CITY OF ALBUQUERQUE

May 4, 2018

Re: Hollow Spirits Distillery
1324 1st NW
Traffic Circulation Layout
Architect's Stamp **04-04-18** (J14-D129)

ACCESSIBILITY SIGNAGE

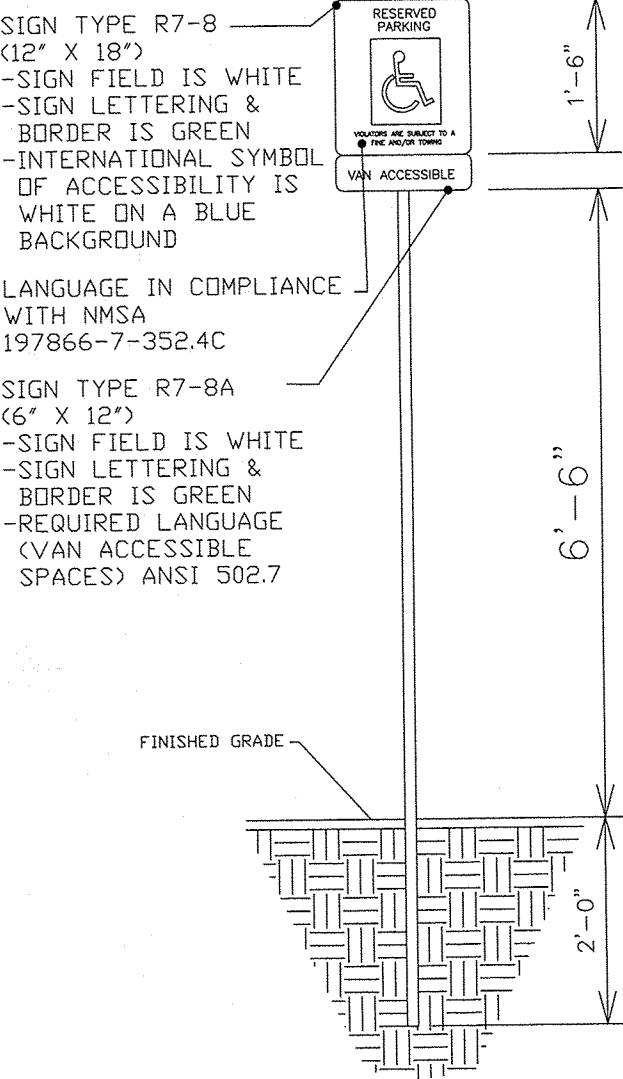
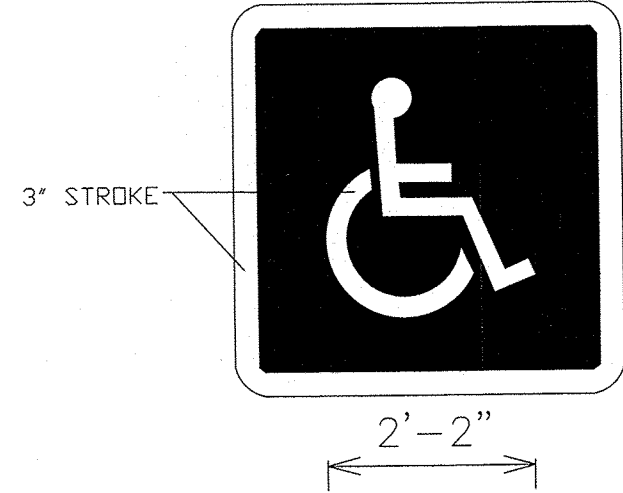
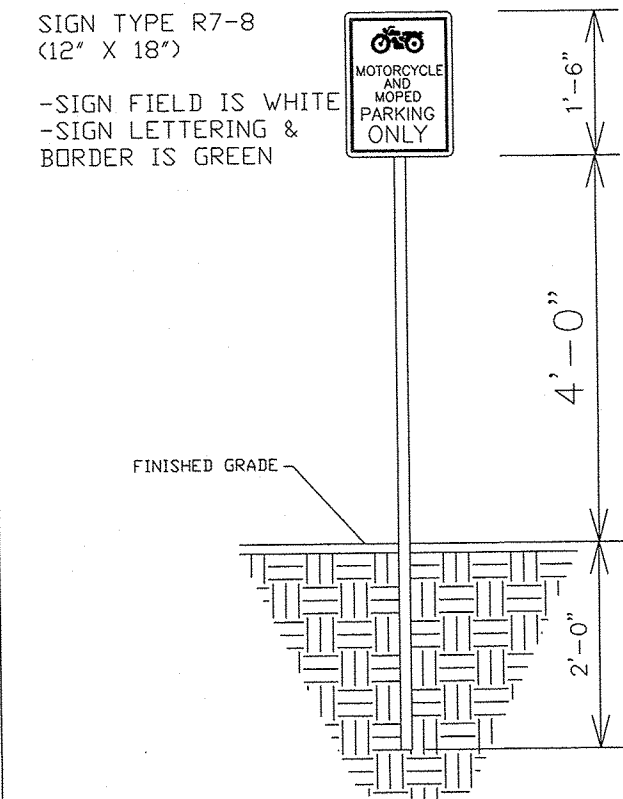
1. A scale of 1"=20' is recommended for sites less than 5 acres. Please make the dimension font larger.
2. Label the compact parking spaces by placing the words "**COMPACT**" on the pavement of each space.
3. Please show the location of the ADA and motorcycle parking signs either free-standing or wall mounted per the zoning code.
4. The handicap accessible spaces must include an access aisle. Van accessible aisles should be 8ft wide; all others should be 5ft wide. ADA parking spaces can be 18 feet long. Would suggest moving one of the ADA spots next to the delivery entrance.
5. A 5 ft. keyway is required for dead-end parking aisles. The landscaping buffer on the northeast side should be adjusted to 5 feet.
